**From:** Simon Davis  
**Sent:** 25 January 2018 16:48  
**To:** Planning.Responses  
**Subject:** FW: Planning Application Ref EG/69/17/PL Swallowfield Nursery, Eastergate Lane

**Subject:** Planning Application Ref EG/69/17/PL Swallowfield Nursery, Eastergate Lane

We received the comments of Eastergate Parish Council on this application on 04/09/17 stating:

Fire Tender	7.334m
Overall Length	2.280m
Overall Width	3.495m
Overall Body Height	0.380m
Min Body Ground Clearance	2.280m
Track Width	5.00s
Lock-to-lock time	6.000m
Curb to Curb Turning Radius

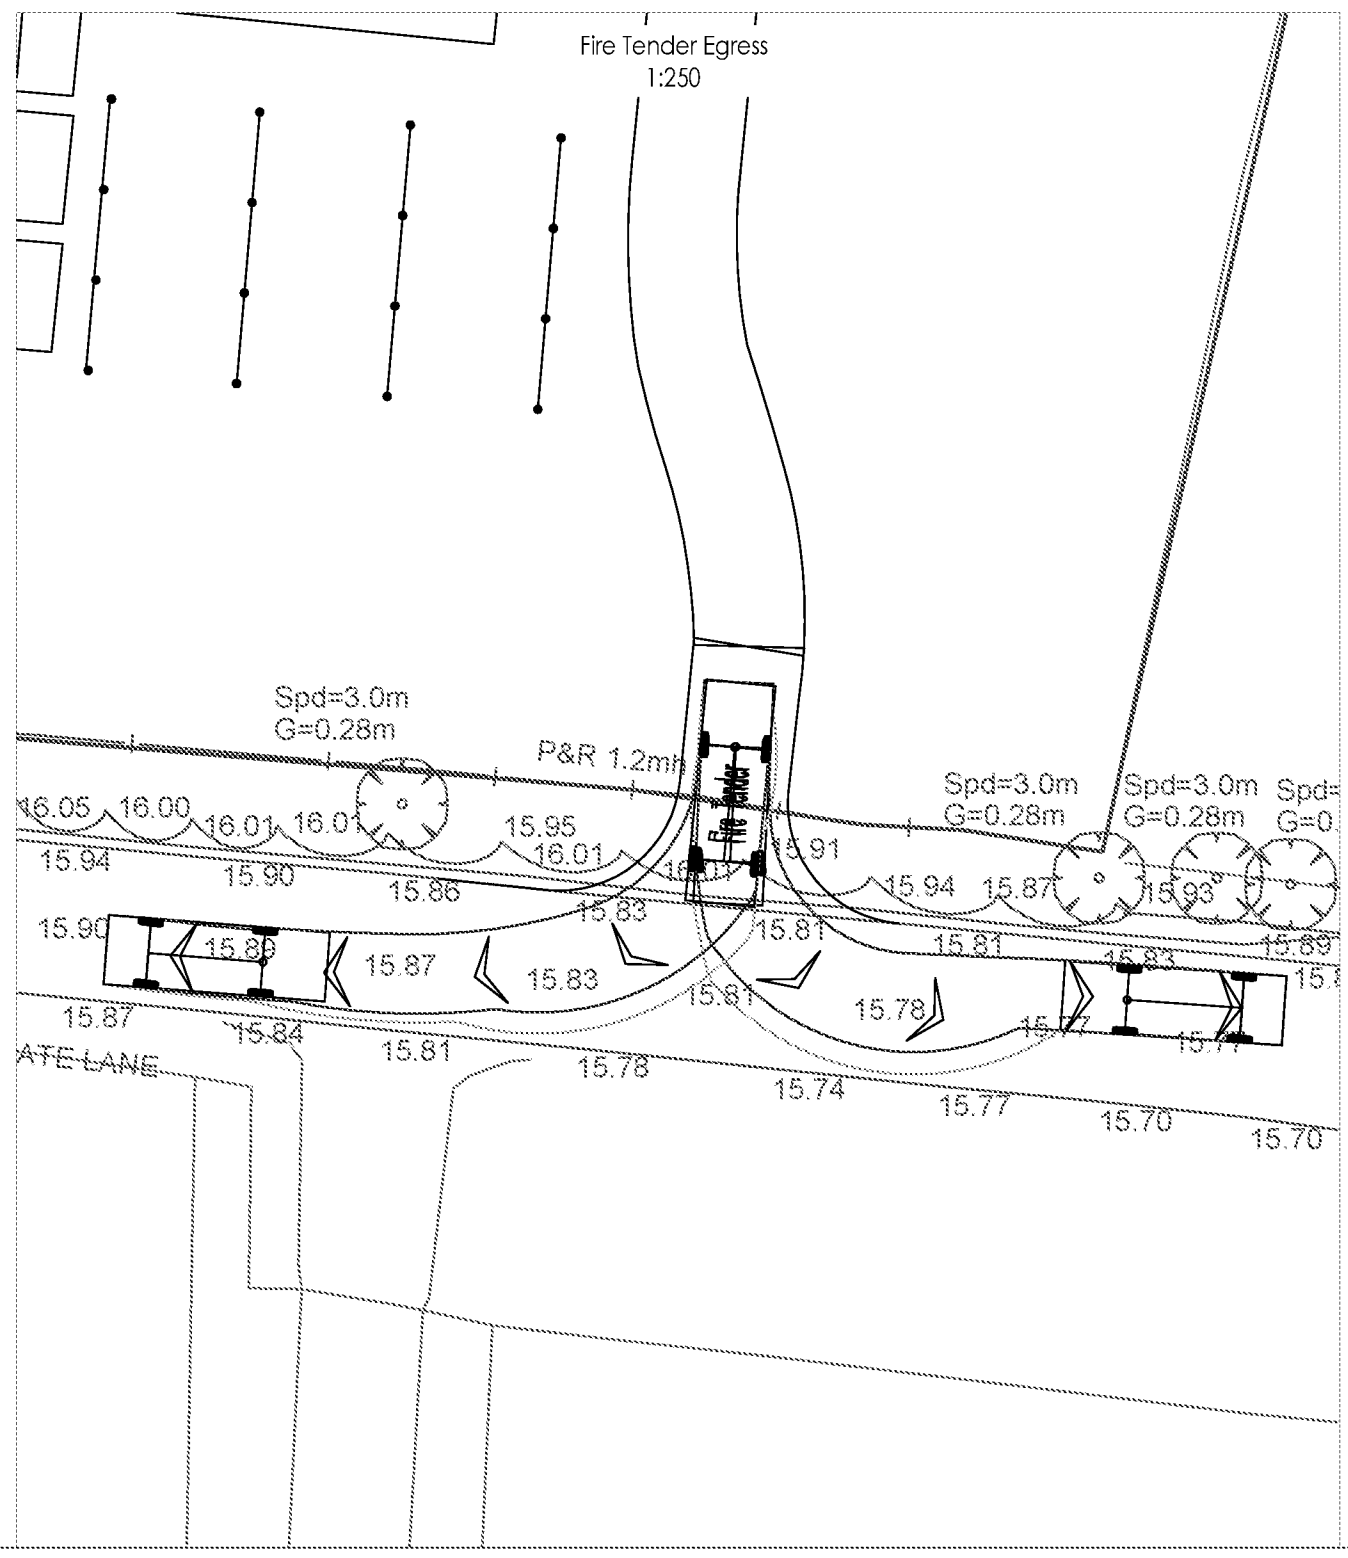
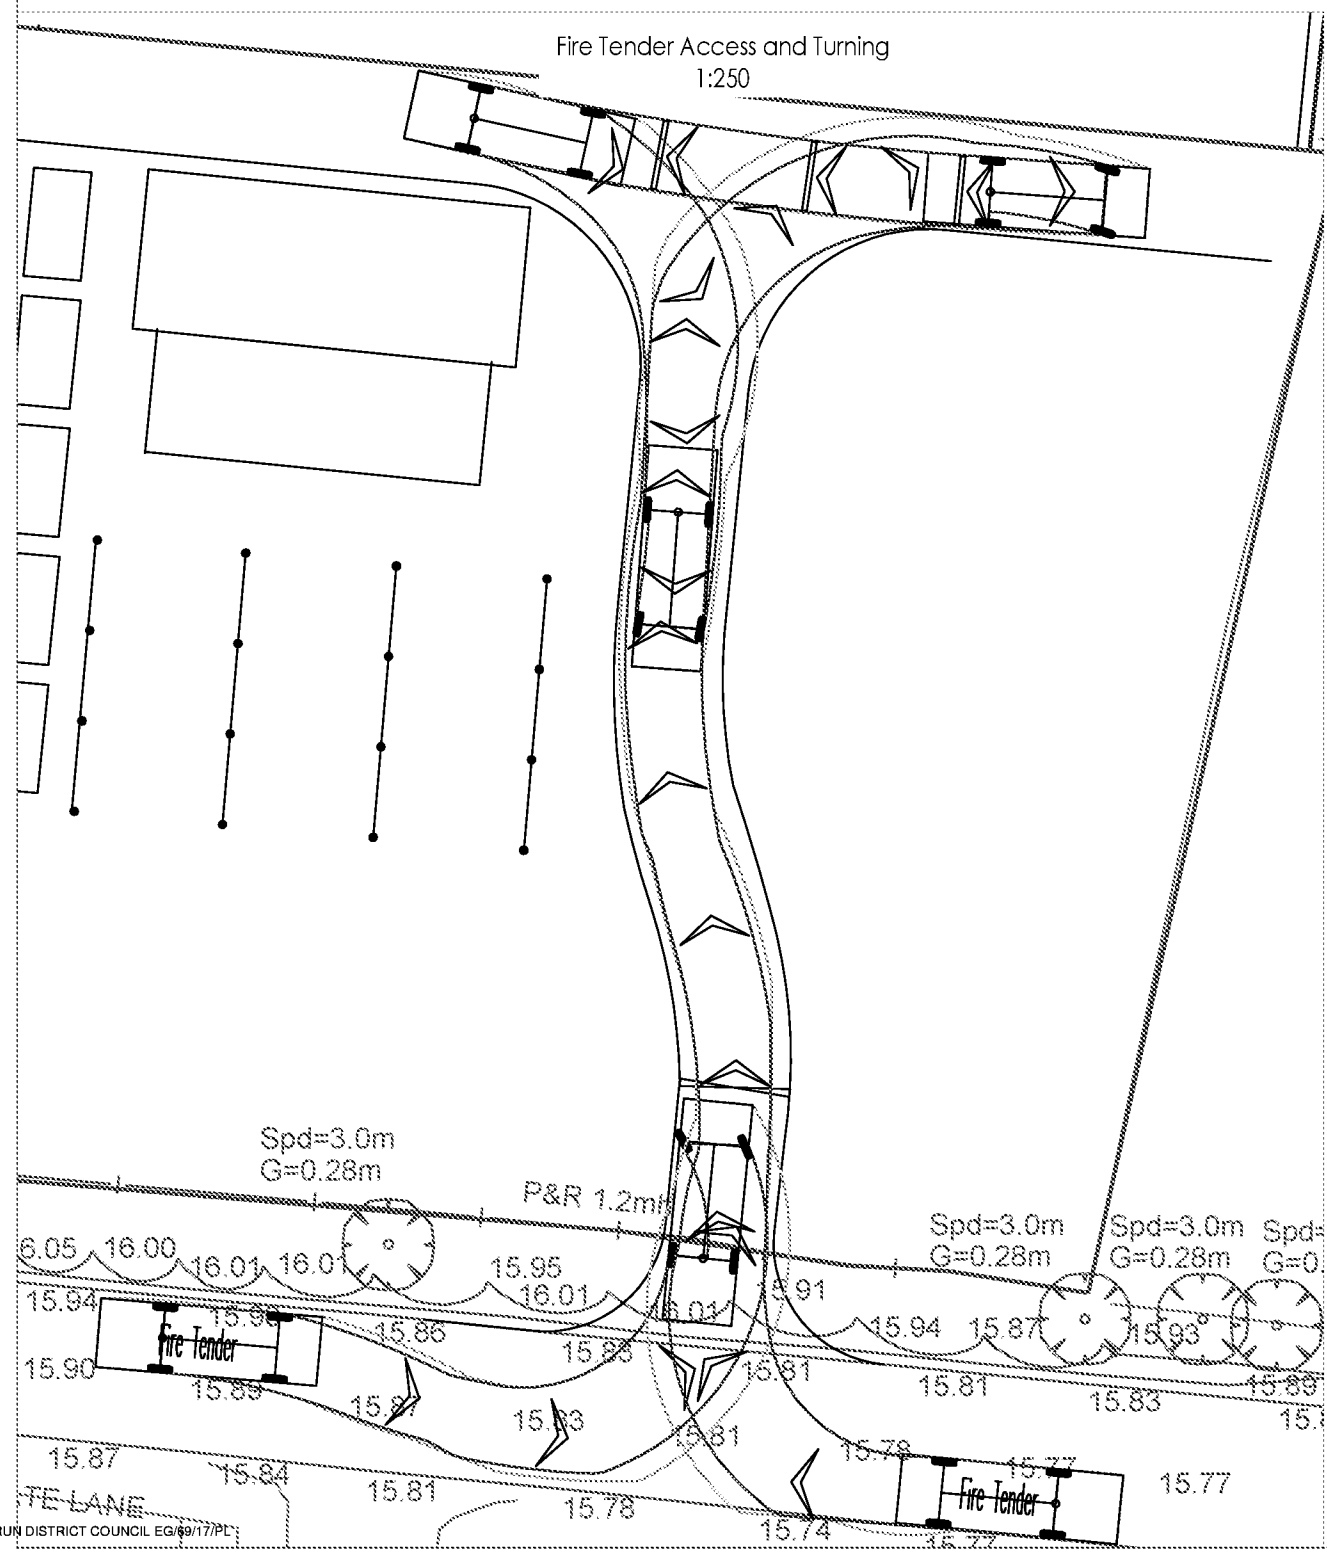
*"OBJECT. The council considers that the application should not be permitted without an allocation of space, on site, for articulated and other vehicles to turn. A condition requiring the use of such turning space should, if possible, be added to any permission."*

We have received a WSCC Highways response which confirms that the turning space on the site would be suitable for larger vehicles including refuse collection and fire appliances. I then asked WSCC Highways about articulated lorries and they commented that they cannot be 100% sure that an articulated lorry could turn with the live/work unit section of the site because of the limitations of the drawings. However, they are mindful of the existing layout with the greenhouses and that with regard to space available to turn on site, this does not appear to be materially different from the existing situation. Furthermore with the reduction in greenhouse at the site & proposed use as live/ work light industrial units. WSCC Highways also question the need for an articulated lorry to serve the site at all.

The applicant has commented that articulated lorries have never been able to turn on the site but also that they have never caused a problem. Visits by articulated lorries are rare but when one does visit, they are supervised and reverse into the site entrance thus allowing them to unload and then exit in a forward gear. It is also contended that the research facility & small live-work units will generate modest levels of traffic and very few commercial movements. The largest vehicles that will service them would be refuse vehicles, which already access and can turn on-site. Also with the reduction in glasshouse space proposed there will be even less reason for articulated lorries to visit the site.

I apologise for my tardy reply. I have been unwell. The Parish Council maintains the view that a turning place for large vehicles would be best but, in view of the ADC position, the council withdraws it's objection and leaves the District council to make the decision.

Please note also that we are unable to impose a planning condition to address an existing issue (occasional visits by articulated lorries) that is not related to the proposal the subject of the planning application.

I therefore write to ask if the Parish Council would withdraw their objection and allow the application to proceed with a delegated decision.
